**Application for Approval of Details Reserved by Condition
Town and Country Planning Act 1990
Planning (Listed Buildings and Conservation Areas) Act 1990**

Discharge condition 3 (ventilation) on previous permission 2014/90017 for change of use and alterations to convert outbuildings into restaurant (within a Conservation Area)

**The Watermill, 24, Station Road, Slaithwaite, Huddersfield, HD7 5AW
Application Number: 2017/91095**

Drawing Title
Planning Drawing - Condition 3

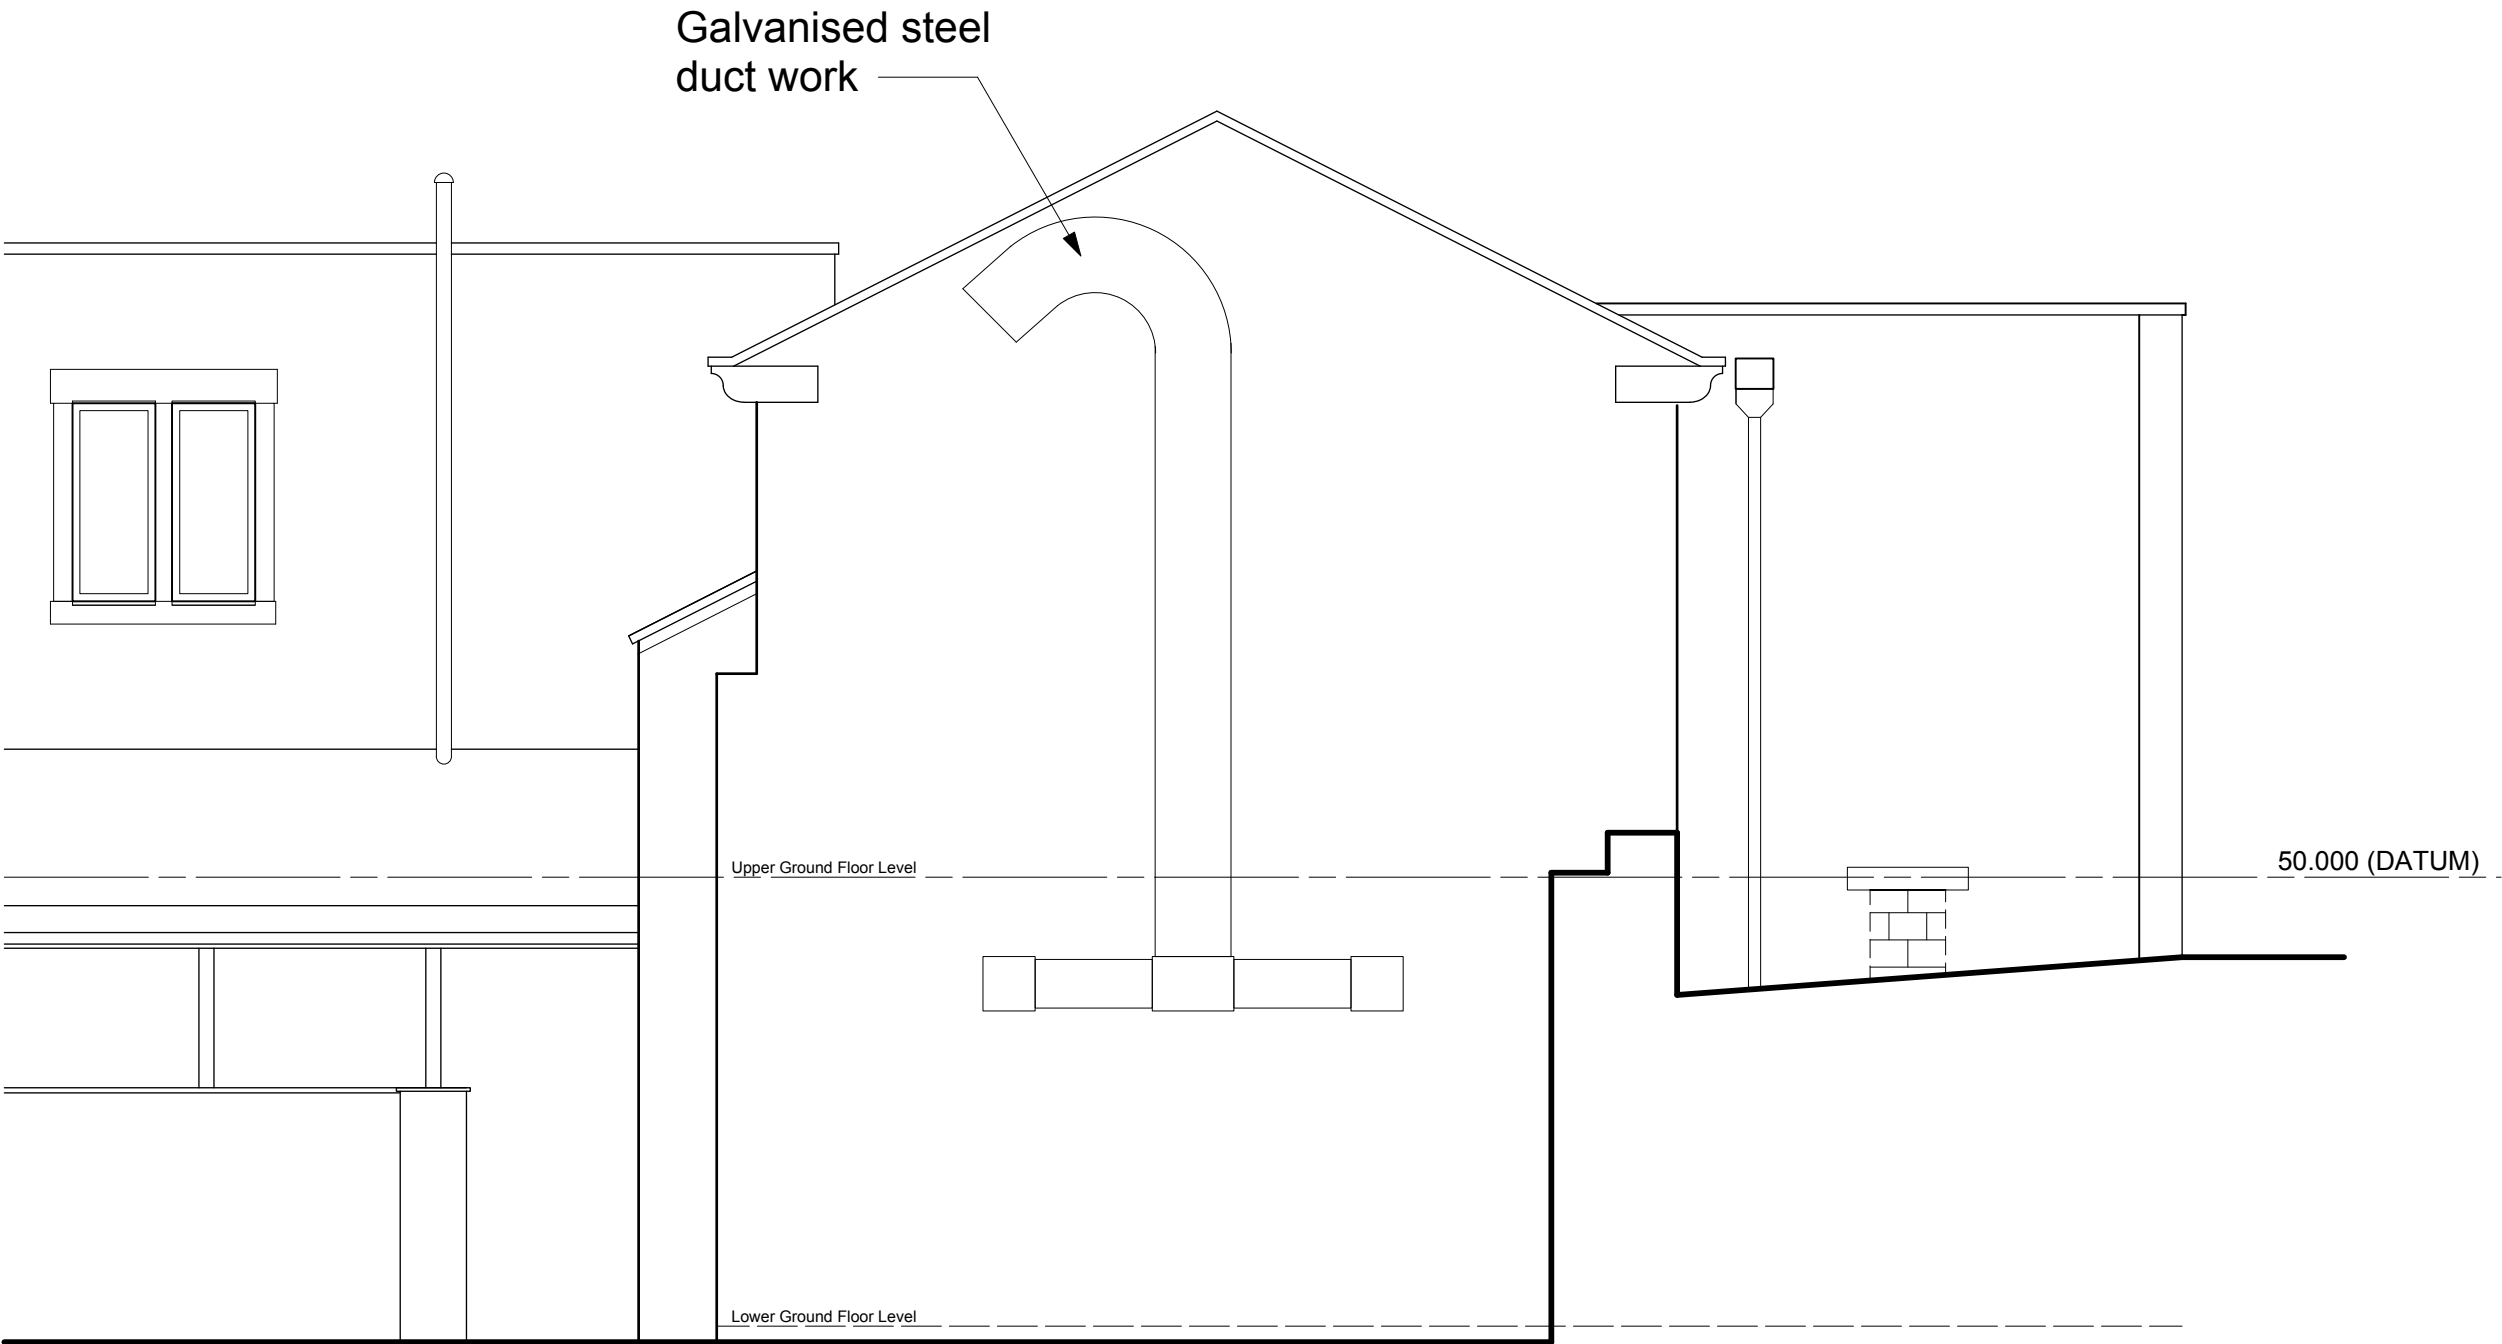
The submitted details fail to deal with odour control. In the absence of information requested in this Authority's e-mail dated 22 June 2017 the condition cannot be discharged. This information can still be submitted as part of this application however, it should be received within 14 days from the date of this letter.
